Ribble Valley Borough Council
Council Offices
Church Walk,
Clitheroe
Lancashire
BB7 2RA

Phone: 0300 123 6780
Email: developeras@lancashire.gov.uk
Your ref: 3/2025/0462
Our ref: 3/2025/0462/HDC/KW
Date: 15 August 2025

Location: Beacon Fell View Caravan Park Higher Road Longridge PR3 2TF
Proposal: Proposed conversion of existing workshop to holiday cottage associated with Beacon Fell View Caravan Park. Proposed works to include creation of first floor and balcony, alterations to roof and insertion of new windows.
Grid Ref: 361577 438114

PROJECT NO: GA3572-PSP-01D

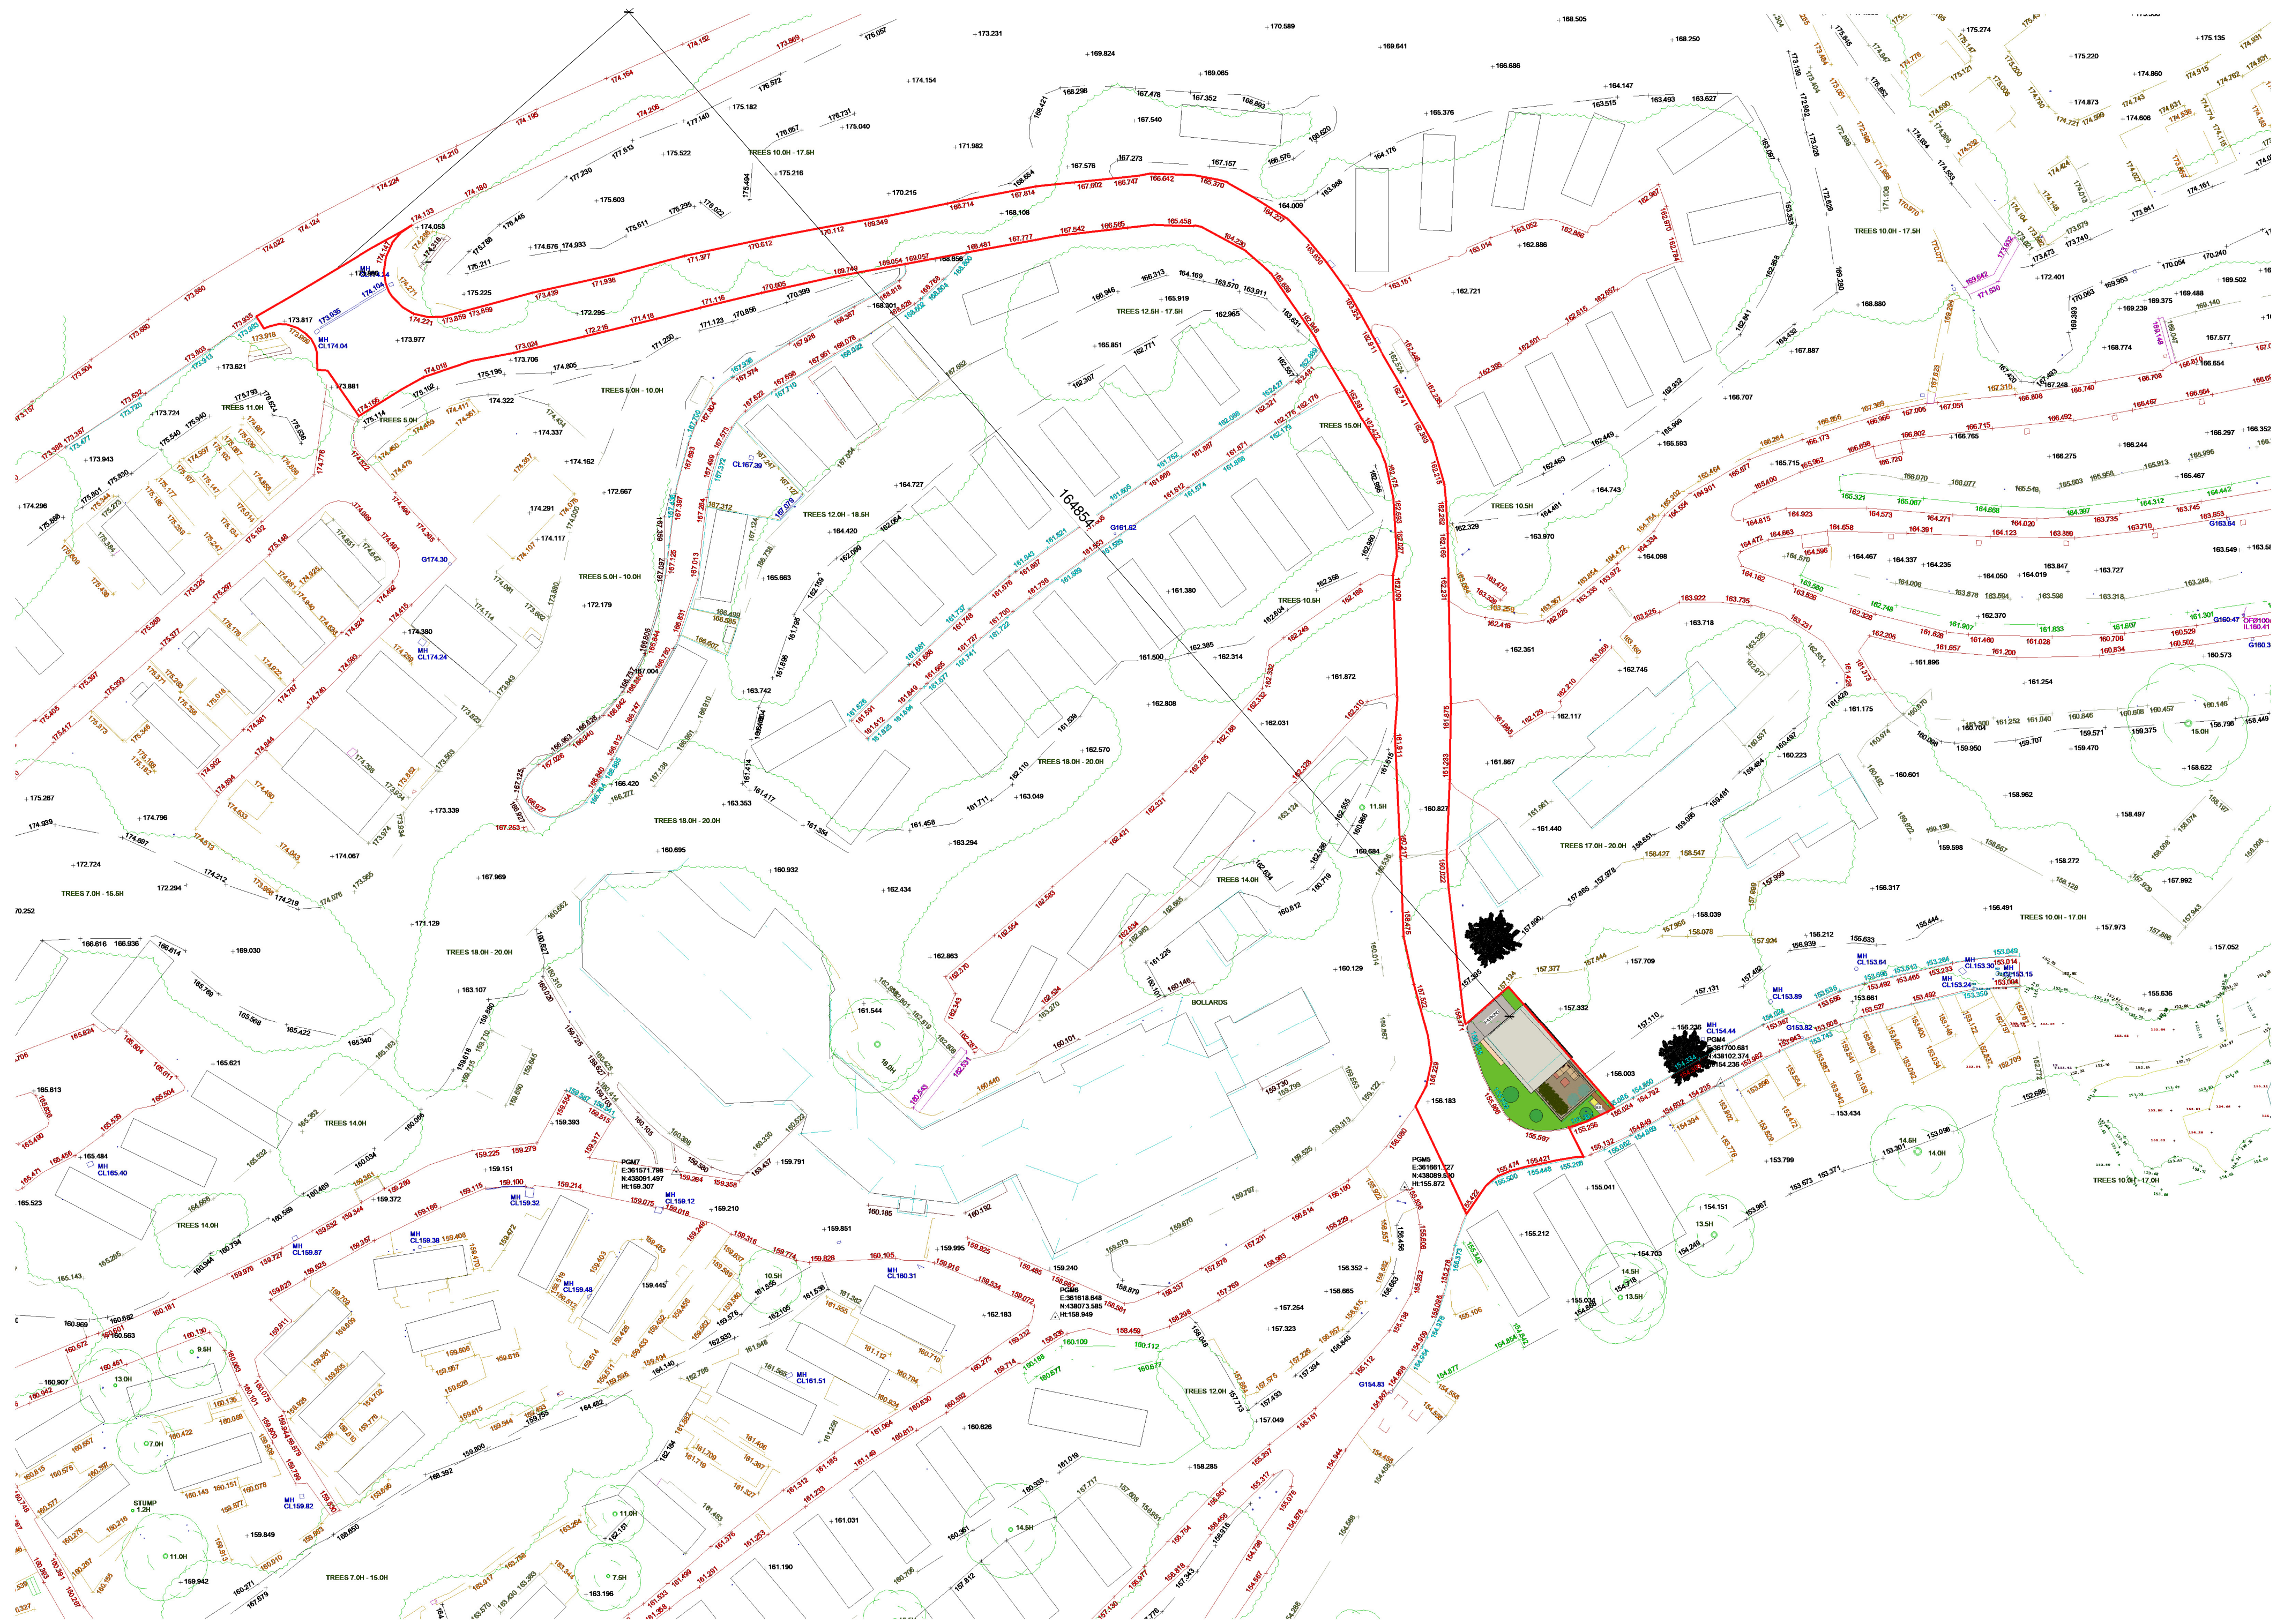
The LHA have reviewed drawing number GA3572-PSP -01D titled "Proposed Site Plan" and is aware that the proposal provides one parking space for the holiday cottage, which is acceptable to the LHA. Therefore, the LHA have no objection to the proposal.

1. The development hereby permitted shall not be occupied or brought into use until the car parking shown on the approved plan(s) has been provided in full and are available for use. The car parking and turning areas shall thereafter be kept available for the parking and manoeuvring of vehicles at all times.
